Date: 05 December 2022

Re: Railway (Metrolink - Estuary to Charlemont via Dublin Airport) Order [2022]
Metrolink. Estuary through Swords, Dublin Airport, Ballymun, Glasnevin and City Centre to
Charlemont, Co. Dublin

**ASHLEY ESTATE RESIDENTS GROUP APPEAL to “Railway
(MetroLink – Estuary to Charlemont via Dublin Airport) Order,
[2022].” CASE No NA29N.314724**

Project	Drawing Title	Drawing Status
Estuary - Seatown Landscape Layout Preliminary Design Issue		S4
Drawing N°	ML1-JAI-ARL-SC01_XX-DR-Y-00001	
Scales Original Size A1	1:1000	Sheet 1 of 3

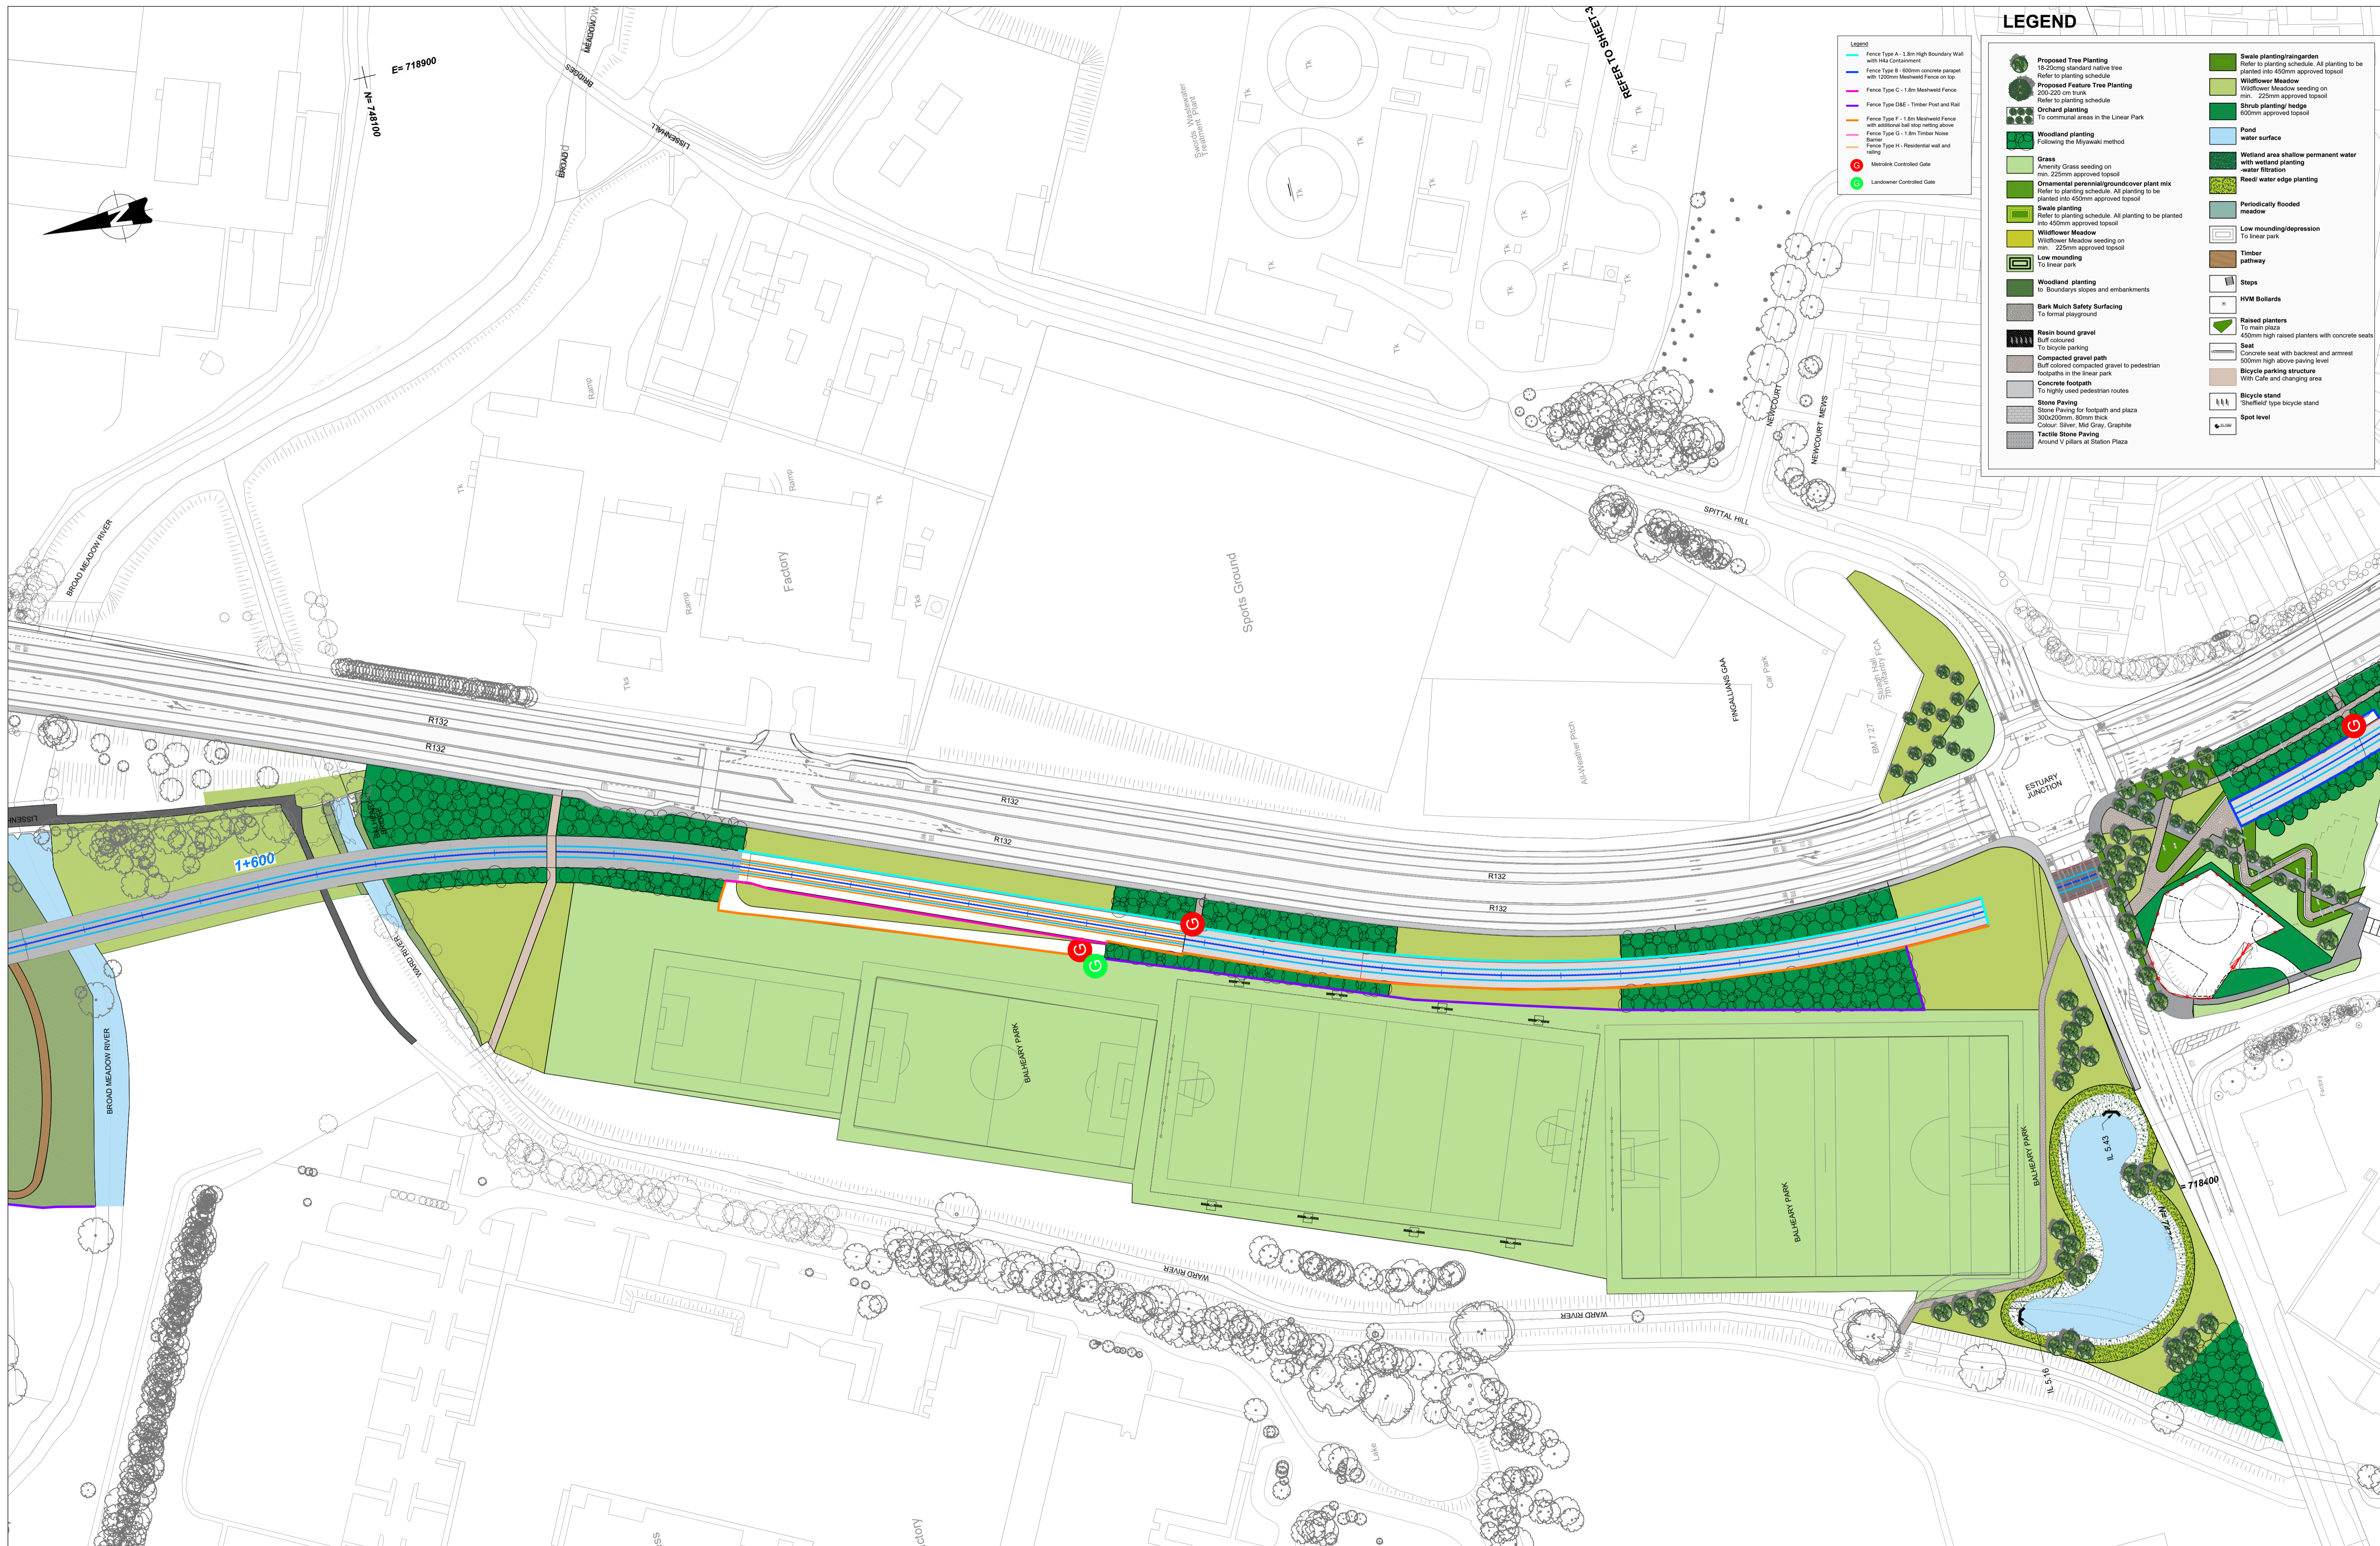
While there have been various iterations of the drawings we have seen for the estate, the latest ones as included in the railway order application, clearly show that despite all our discussions regarding the Metro line, our estate is being radically altered and will lose its overall look and feel and much of the existing amenity and sense of security associated with the green space, should the plan go ahead without alteration.

- A significant number of additional walkways are planned throughout the green area (an increase from 3 to 9 walkways) which will substantially reduce the actual useable green area.
- The volume and placement of new trees and shrubs severely impacts upon the useful play area of the estate (e.g., no adequate space for children to play football or other games).

- The indicated number of breaks in the wall as it is to be positioned along the R132 has increased from the current 2, to a total of 9.
- The positioning of said wall would seem to encroach within the current boundaries of our estate further impacting on the amenity we have enjoyed and nourished for 40 plus years.

- There are also some concerns as to the type of wall that is planned to replace the existing wall and clarification on this needs to be made. We have seen differing report to suggest a low wall with railing on top to a solid wall as is the current position.

- The loss of the current footbridge over the R132 and its replacement with a new Toucan crossing which will lack the safety for the very young and the old and infirm.

- While we recognise that the R132 is to be ‘de-trafficked’ and narrowed we are also very worried that younger children especially, may be easily able to run out into the roadway, perhaps chasing a ball that might have flown through one of the many new entrances in the wall, and onto what will still be a major road. The footbridges and the completed wall provide a good level of safety for our most vulnerable residents in respect of this road.

- **Wall and Type** - Bearing in mind the type of wall. Reinstatement the boundary wall between Ashley Green and the R132 to as near the R132 as it currently exists. The green has provided a safe and secure open space for all.

- **Green area** - Reinstatement the green to retain the aspect that it currently has, in order to retain this highly cherished amenity value. There is no need or desire for all the planned footpaths.

- **Tree planting** - Replant mature trees along both sides of the reinstated boundary wall to provide sound deadening of traffic on the R132, and the visual aspect that we currently enjoy and have done for decades. Indeed, the Metro project already acknowledges that the noise endured by the residents from traffic along the R132 is loud enough even with the mature trees along the boundary.

- **Opening in boundary wall** - Replicate the current 2 openings in said wall with one at the proposed toucan crossing along the R132, thereby retaining safe access to and from the Swords side of Chapel Lane, and one at the exit to the R132 to allow for foot traffic to access the crossing at the new junction replacing the Malahide roundabout.

- **Footbridge across the R132** - While realising that there may be some engineering implications relative to the Metro line itself, we can concede that its retention on this specific basis may not be possible. However, we would suggest that the footbridge be retained as it provides a much safer access route across the R132 rather than a Toucan crossing. We say this based on consideration for the most vulnerable members of our community and indeed to retain such safety benefits for the whole community of Swords that use this bridge daily.
